My reference: 3/2025/0270

Date: 21 May 2025

Location: Lower Reaps Farm Whinney Lane Mellor BB2 7EL

Proposal: Approval of details reserved by conditions 3 (materials), 4 (window and door specifications), 5 (details of roof lights), 7 (building recording and analysis), 11 (electric vehicle charging point), 13 (landscaping) and 17 (drainage) of planning permission 3/2022/1165.

lower reaps farmhouse 24.48
proposed - section details
scale 1 to 20 @ A1 date february 2025 status discharge of conditions
drawing number dis.01
revision A

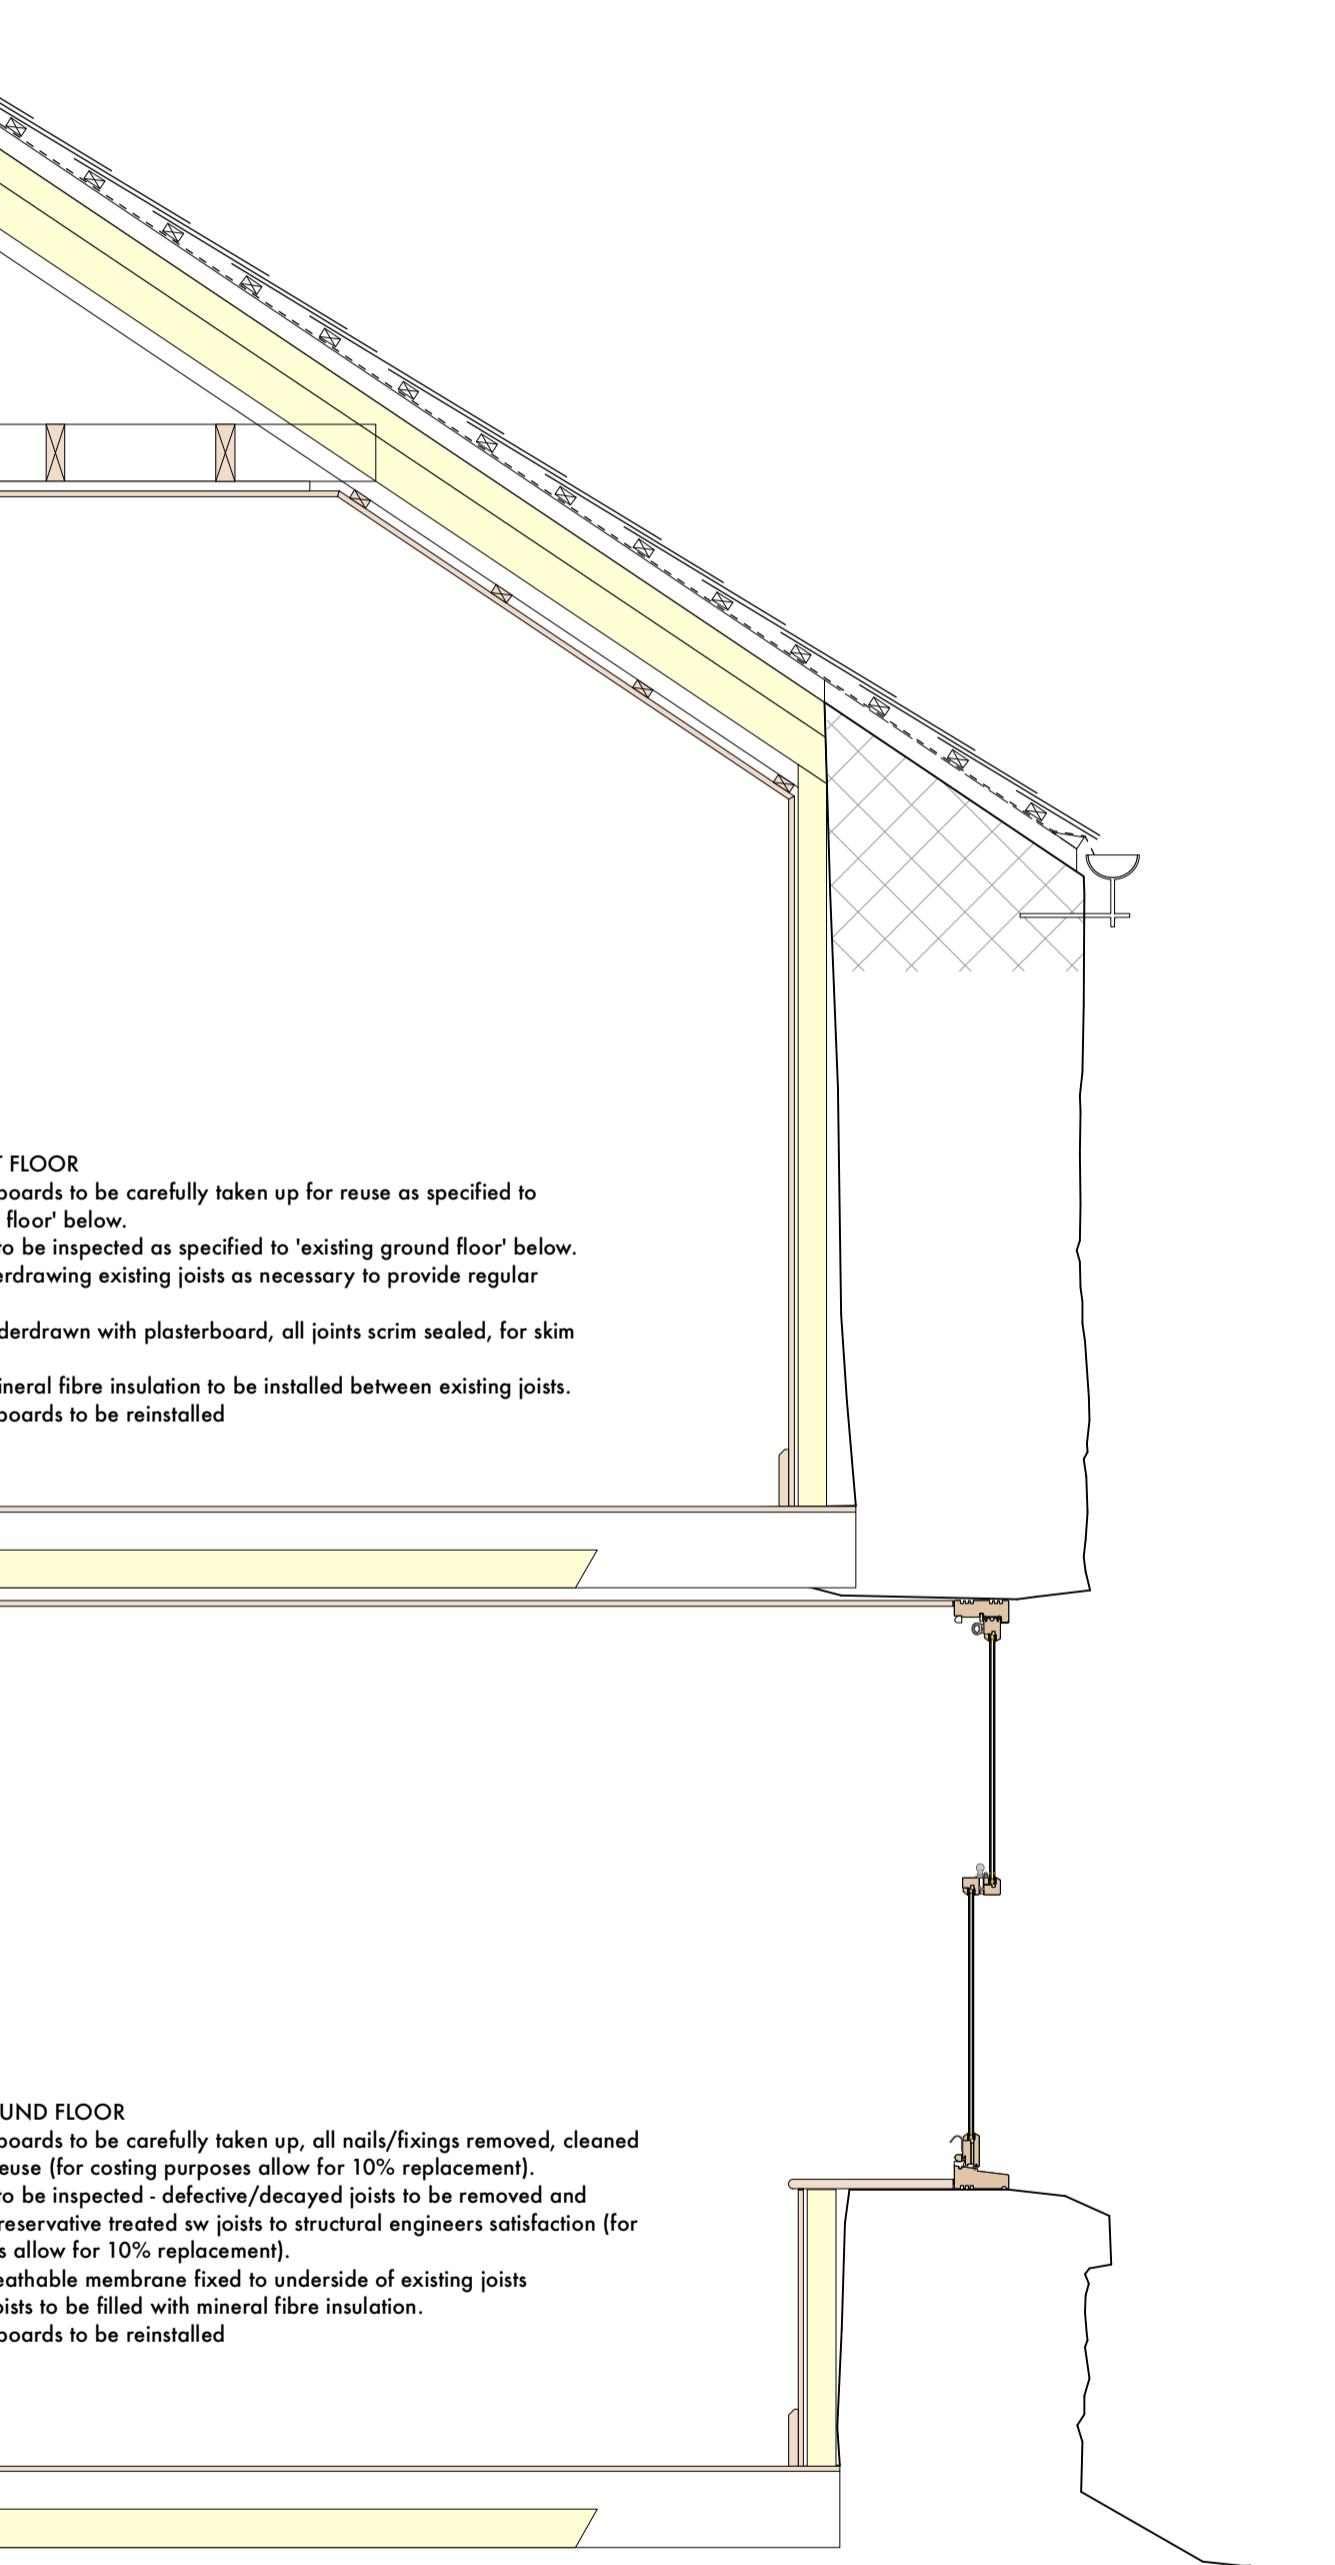
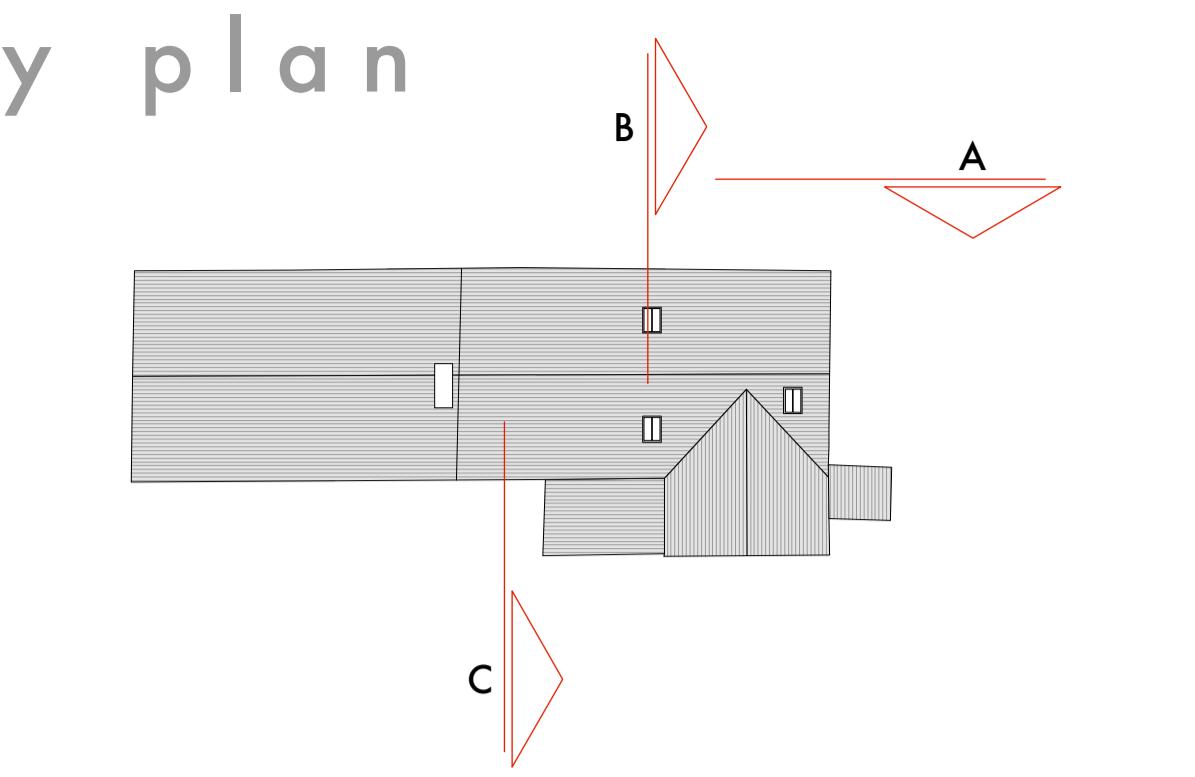
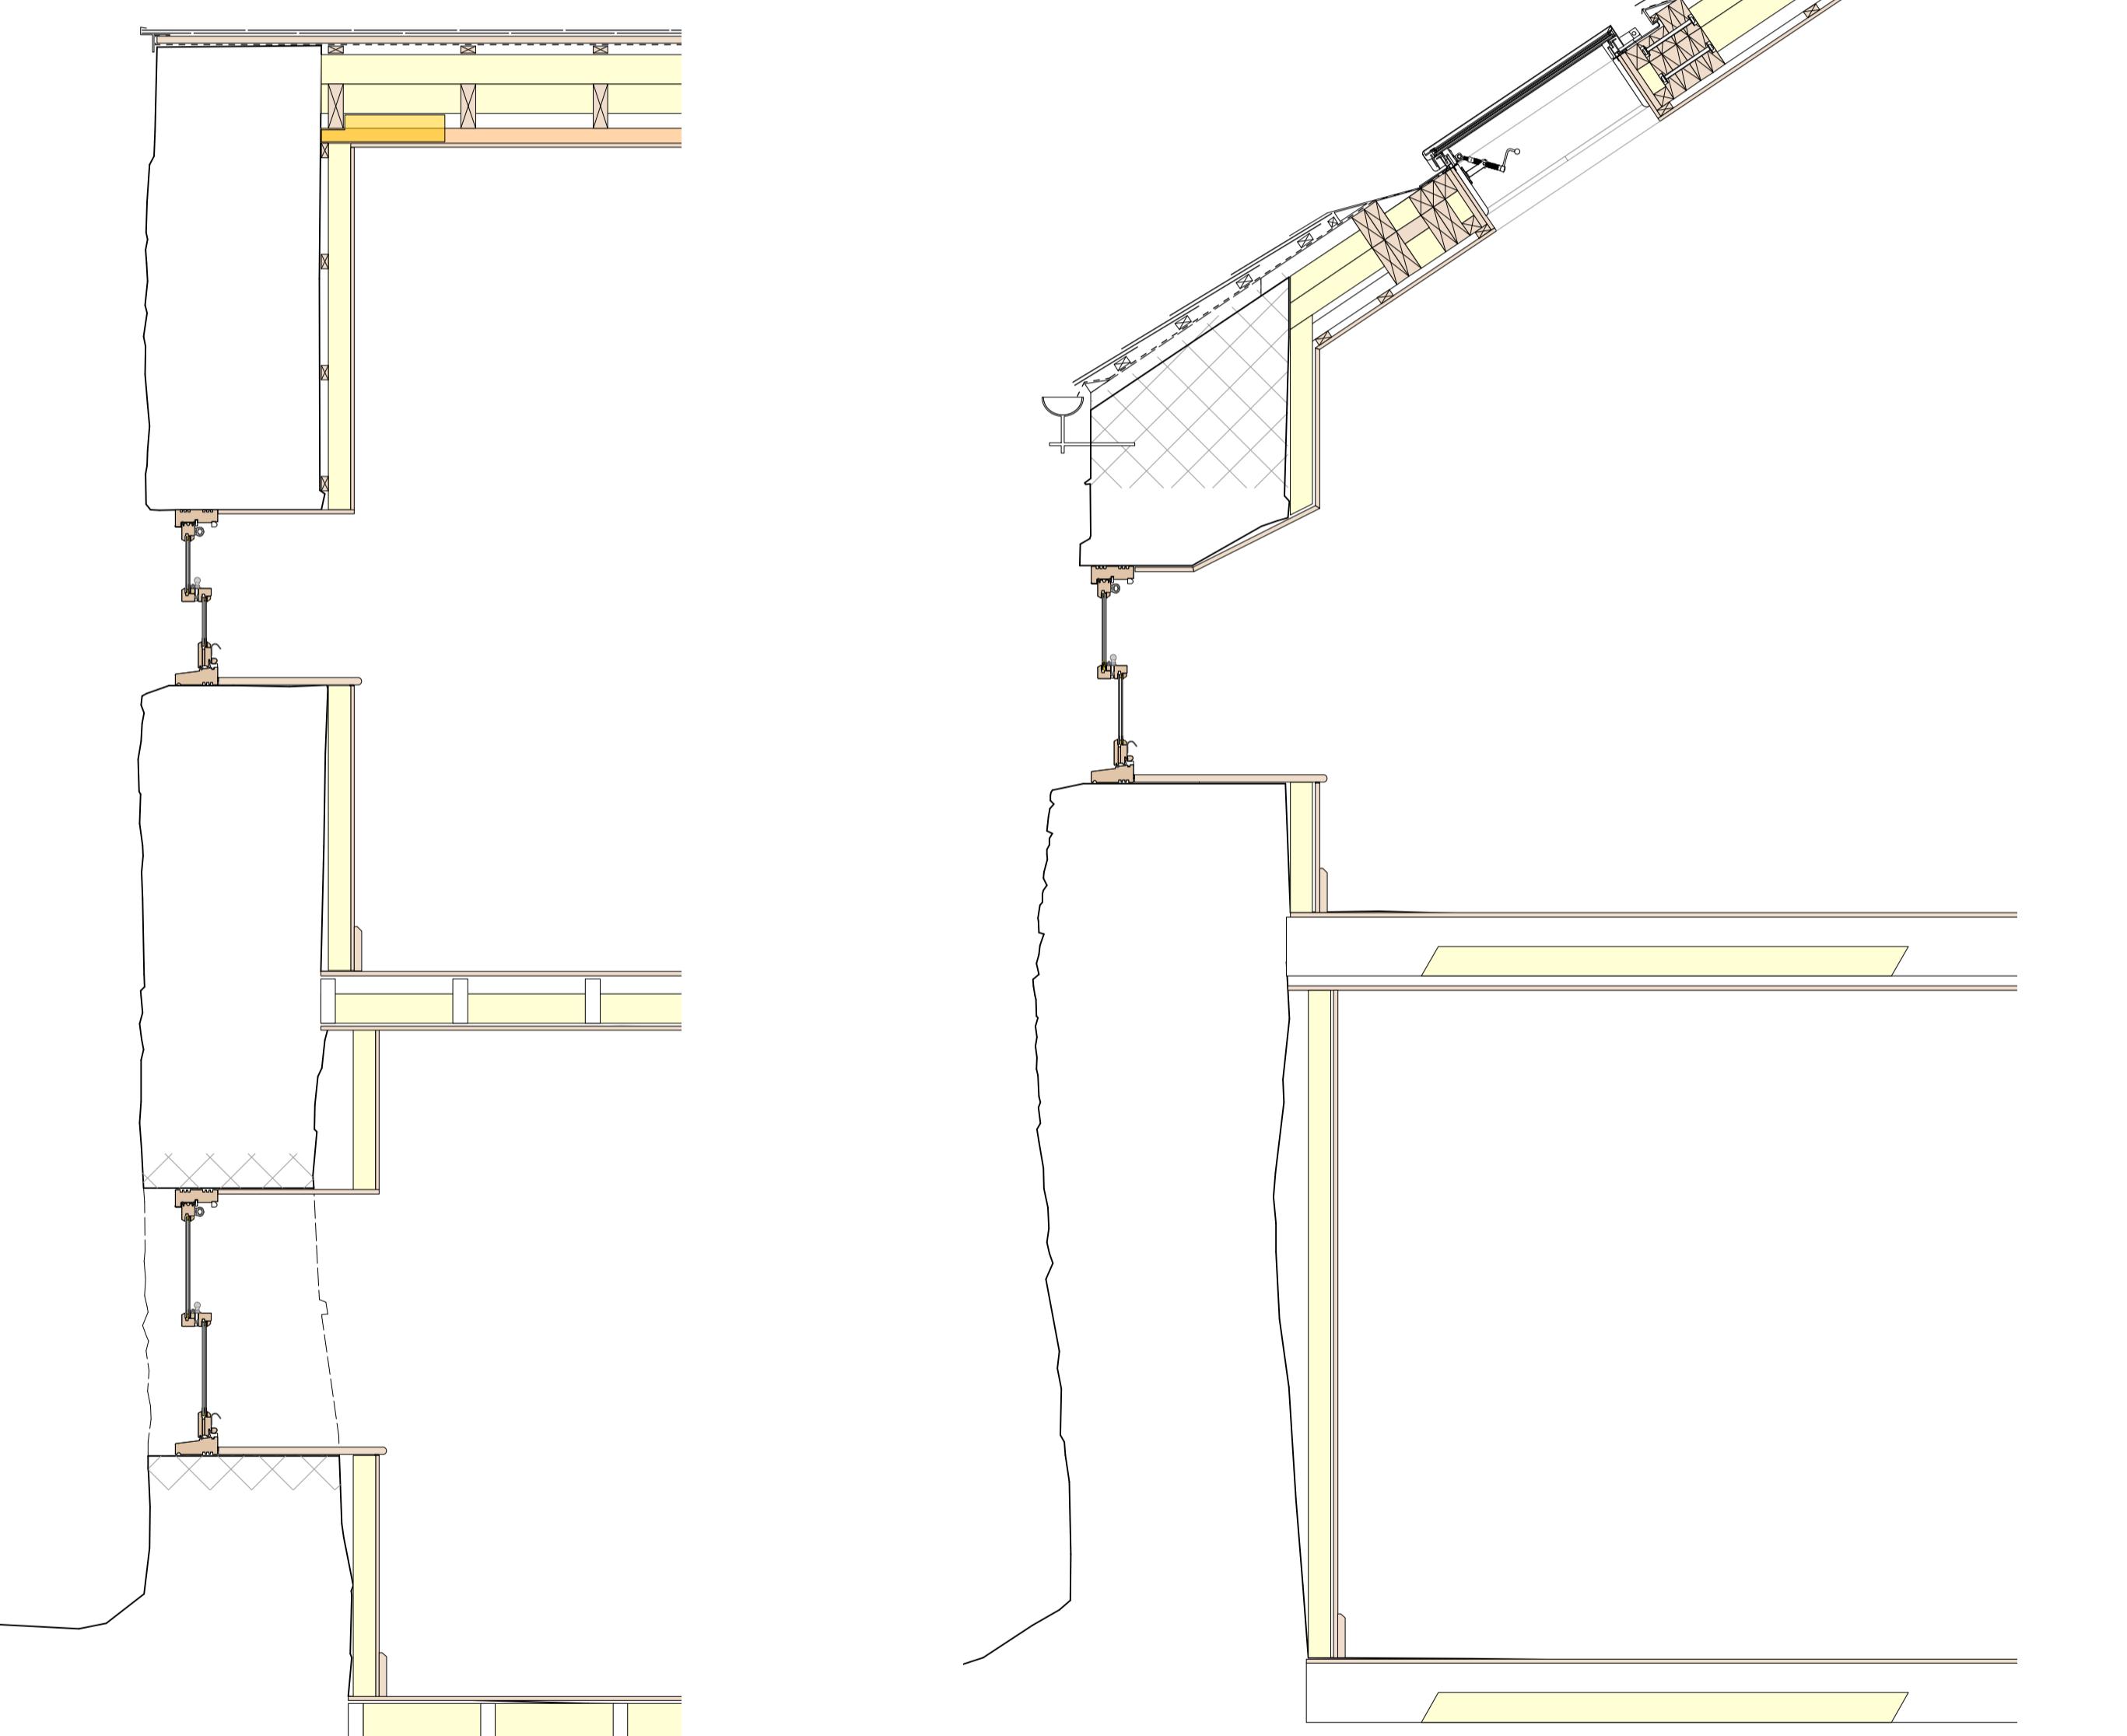
Condition 5 (details of roof lights) - The submission includes a proposed section drawing which notes that the proposed rooflights will be conservation rooflights and will be installed flush with the roof '*between the rafter installation*'. This is acceptable and Condition 5 can be partially discharged insofar that the approved rooflights shall be implemented in strict accordance with the approved details and shall thereafter be retained in perpetuity.
